To: Kittitas County Community Development Services
Mackenzie Moynihan, Staff Planner

Subject: F & G Performance Based Cluster Plat (LP-08-19)

**F & G  
PERFORMANCE BASED CLUSTER PLAT**  
PTN. S 1/2 OF SECTION 7, T. 19N., R. 15E., WM.  
KITITAS COUNTY, STATE OF WASHINGTON

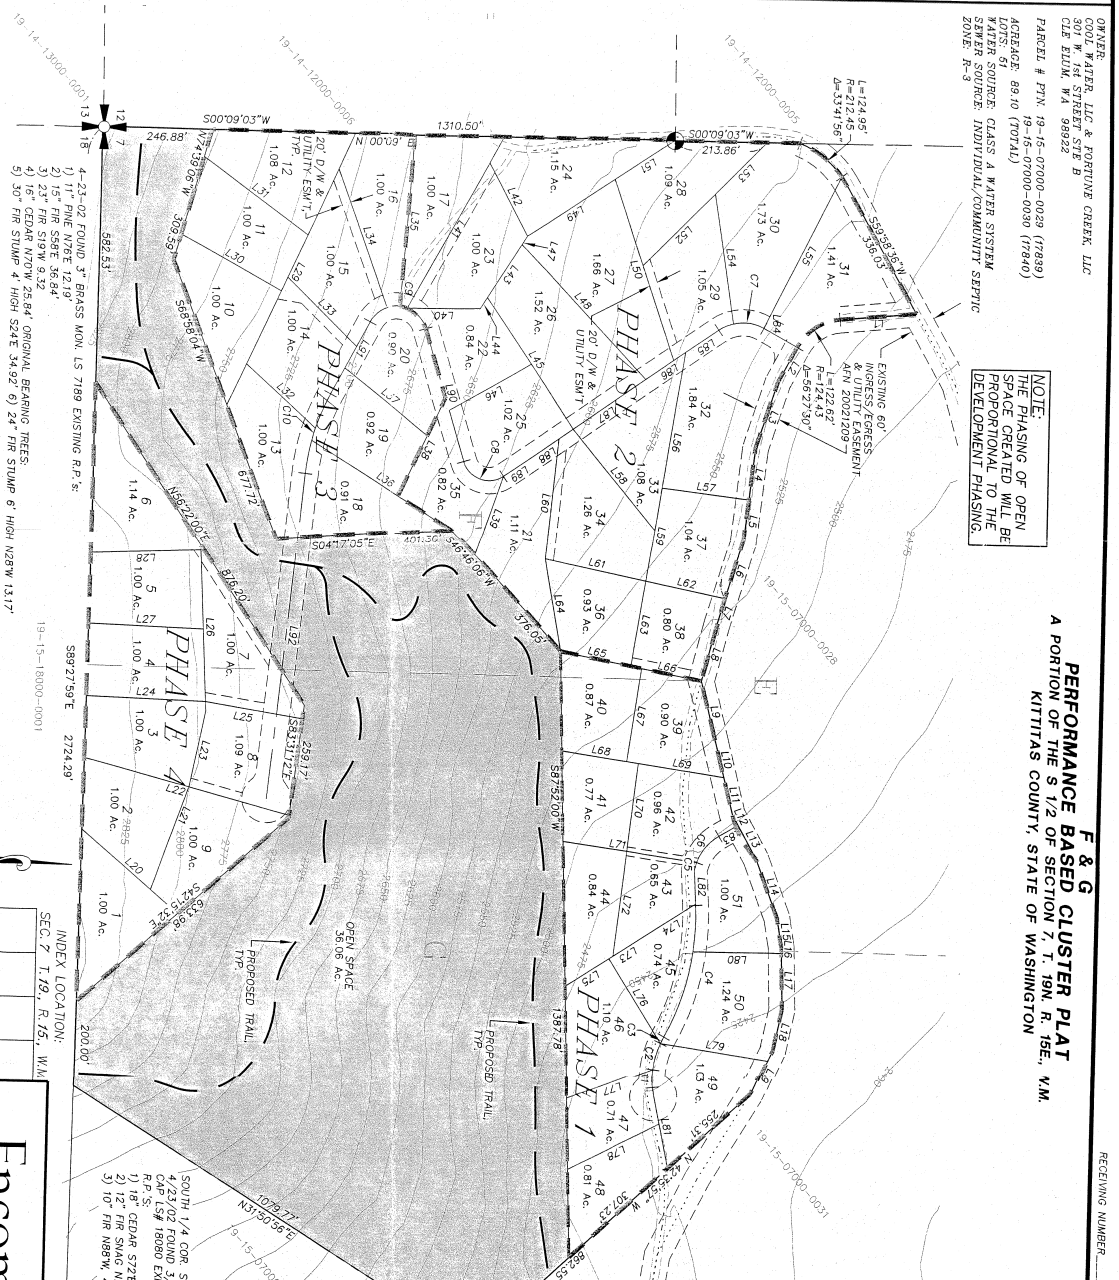
Referencing the proposed cluster plat, Kittitas County Fire District 7 has specific concerns related to this development. Outlined in the notice is the proposal for a class A water system, but no mention of hydrants to protect this development. Being remotely located and backed up against the mountains in an urban wild-land environment with additional developments in planning, the fire district strongly requests that an appropriate water system be developed to provide fire flows for a hydrant system that is evenly spaced no more than 600 feet in separation. The system should meet minimum fire flows for residential development.
